Walsh Bay Arts Precinct Stage 2 (SSD 7689)

Thank you for providing the Port Authority of NSW (Port Authority) with the opportunity to review and comment on SSD 7689 (Walsh Bay Arts Precinct).

DRAWING NO.
FIGURE 4.1

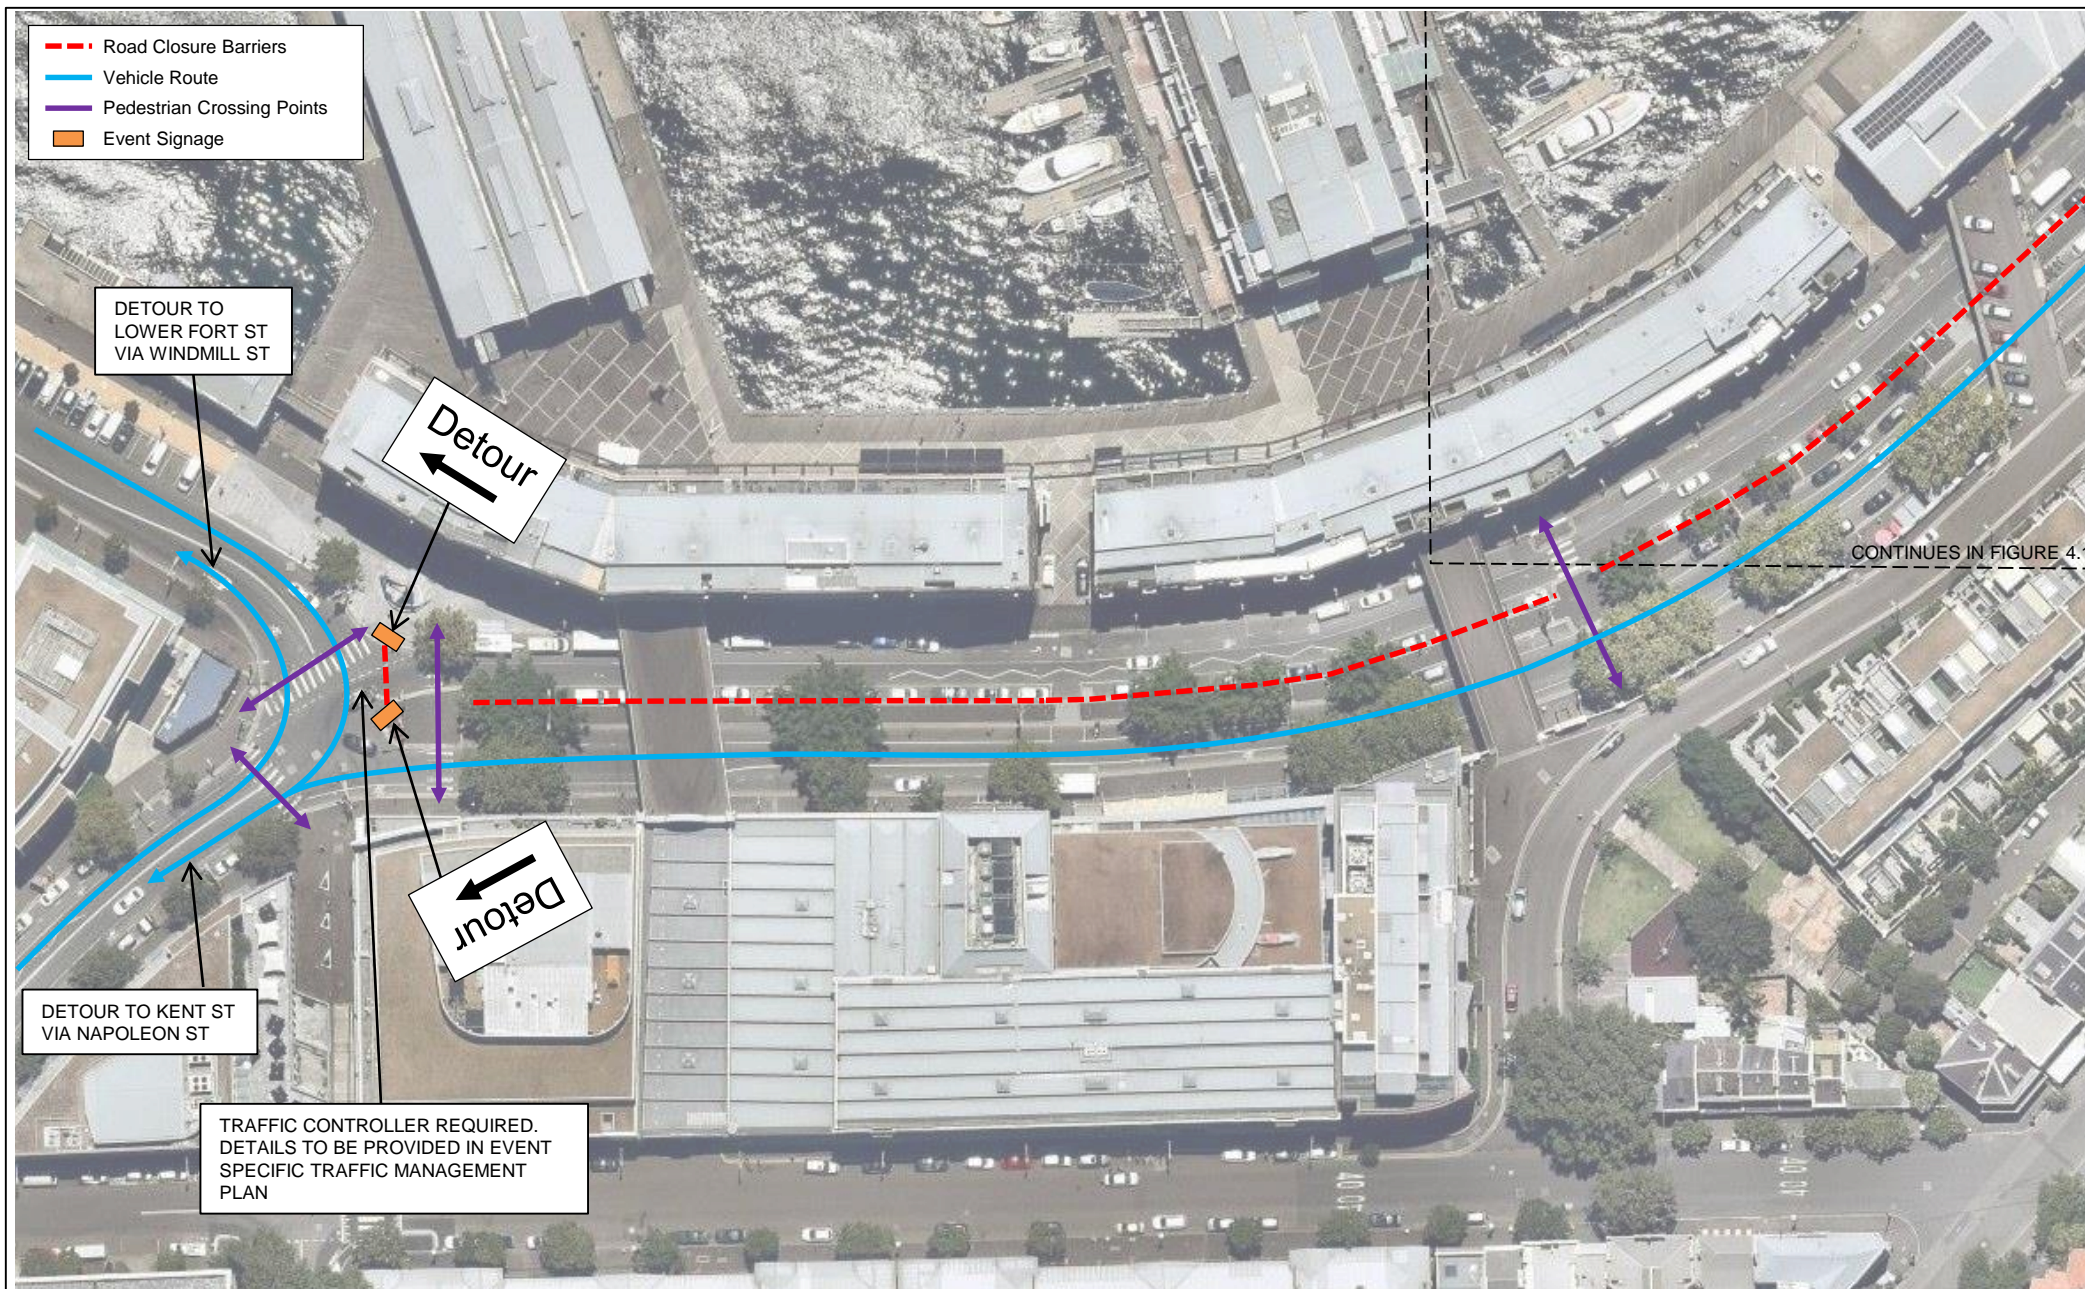
The Port Authority is also concerned about the proposed closure of Hickson Road for City Wide Events (Event Categories 1 and 2) as noted in Figures 4.1 and 4.2 of the Event Transport Management Plan. If any proposed road closure were to coincide with required delivery times to the OPT associated with cruise ship operations, it would need to be demonstrated that 19m articulated semi-trailer container trucks could utilise the suggested detours (Figure 4.3) and that the detours would not adversely impact the logistics and timing of the required OPT operational traffic.

The Port Authority therefore requests that coordination with the Port Authority be required for any proposed closures of Hickson Rd at the construction and operational stages of SSD 7689 to ensure that operational traffic access to the OPT is maintained.
